2316/A1/01

CRITICAL PEER TO PEER REVIEW

FULL PLANNING APPLICATION FOR A REPLACEMENT DWELLING WHINNEY CLOSE FARM, KIRKHEATON

SOUTH SECTIONAL ELEVATION AS EXISTING

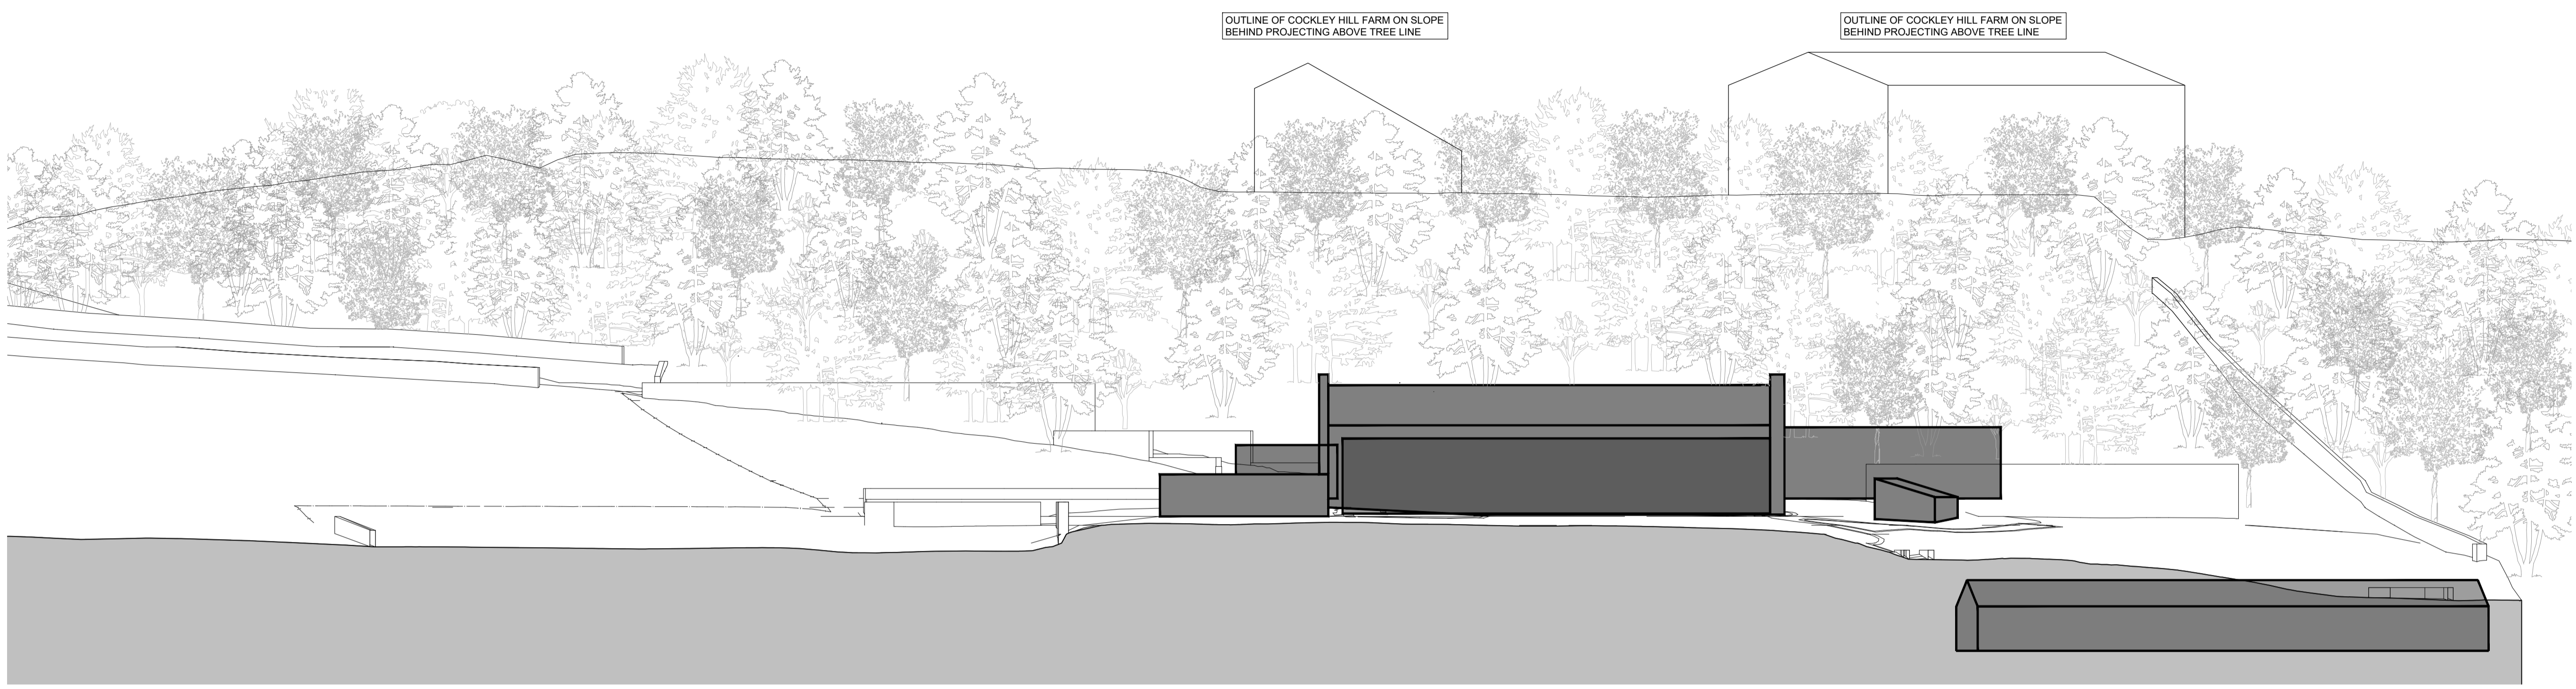
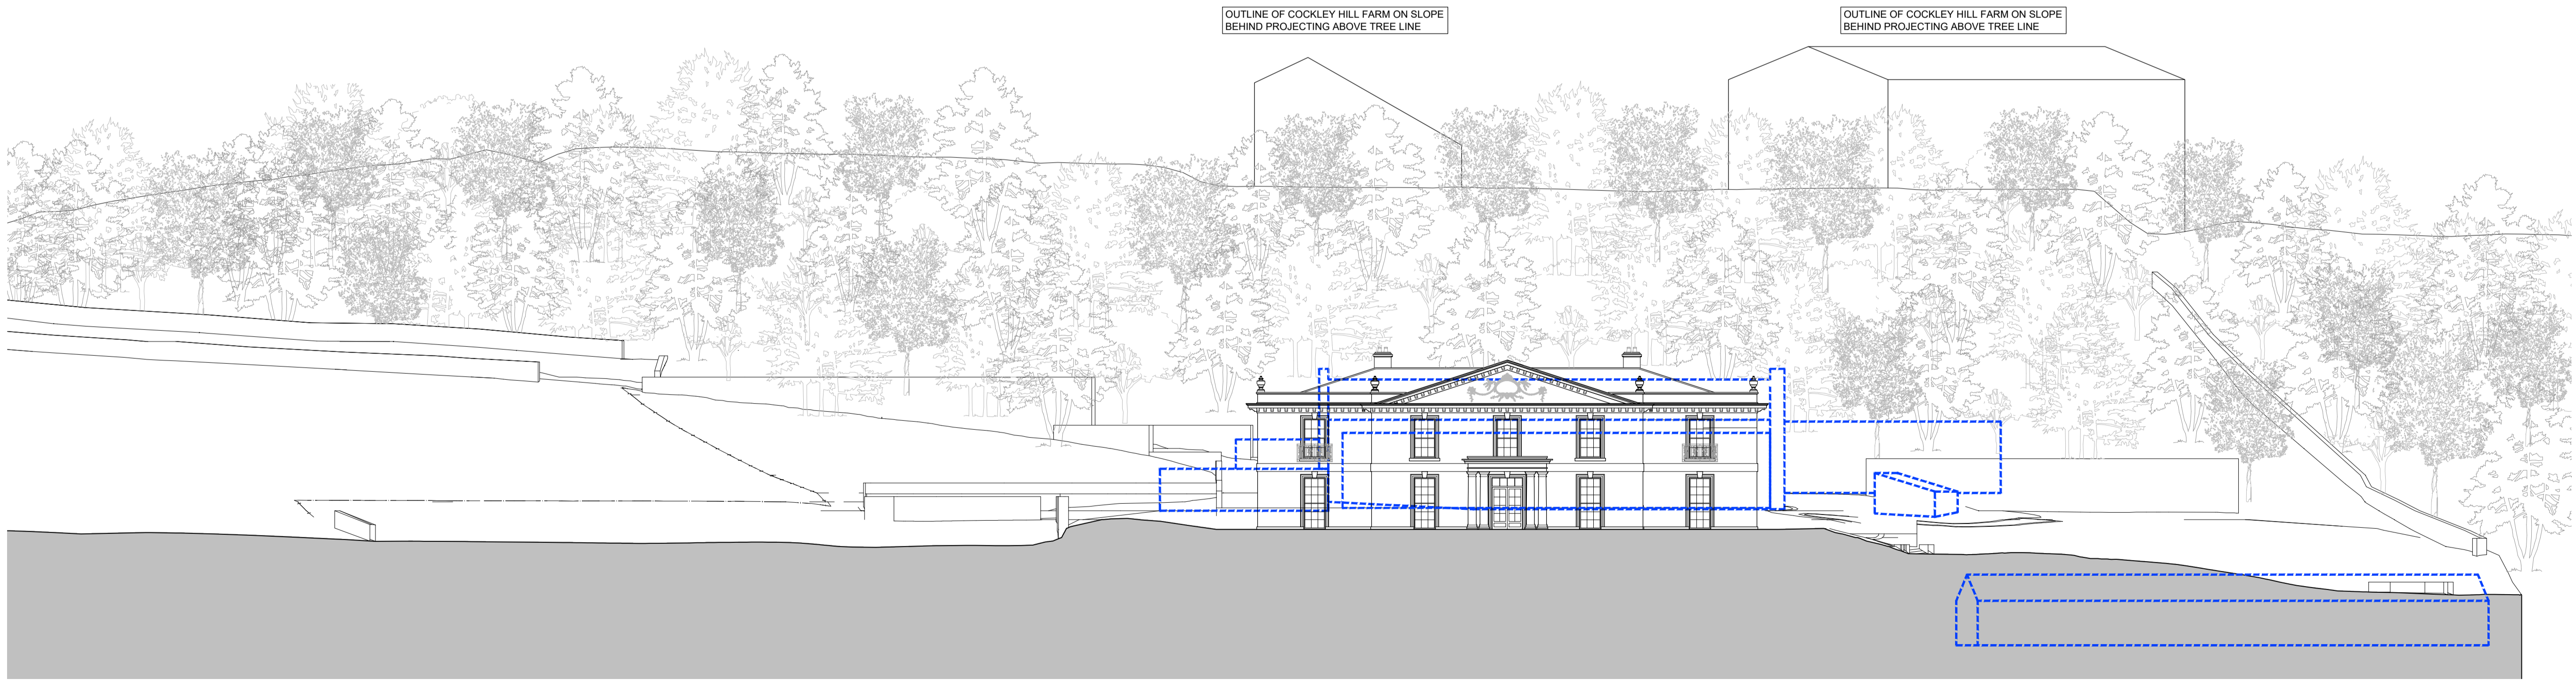
Given that the openness of the site can only be perceived from the south, I consider a key measure of the replacement dwelling's impact on the openness of the Greenbelt to be its impact from this direction. Both the existing dwelling and the replacement dwelling are seen as silhouettes against the backdrop of the wooded escarpment.

The south elevation of the current dwelling has an area of 232 square metres measured from grade. The south elevation of the replacement dwelling has an area of 323 square metres, representing an increase in area of 39%. If the applicant were to consider lowering the plateau on which the replacement dwelling is located by 900mm such that the southeast corner of the plateau is no longer elevated but also at grade, the area of the south elevation would reduce to 296 square metres representing a 27.5% increase in area.

I do not consider either of these percentage increases to be materially larger than the building being replaced, therefore both satisfy the requirements of LP57.
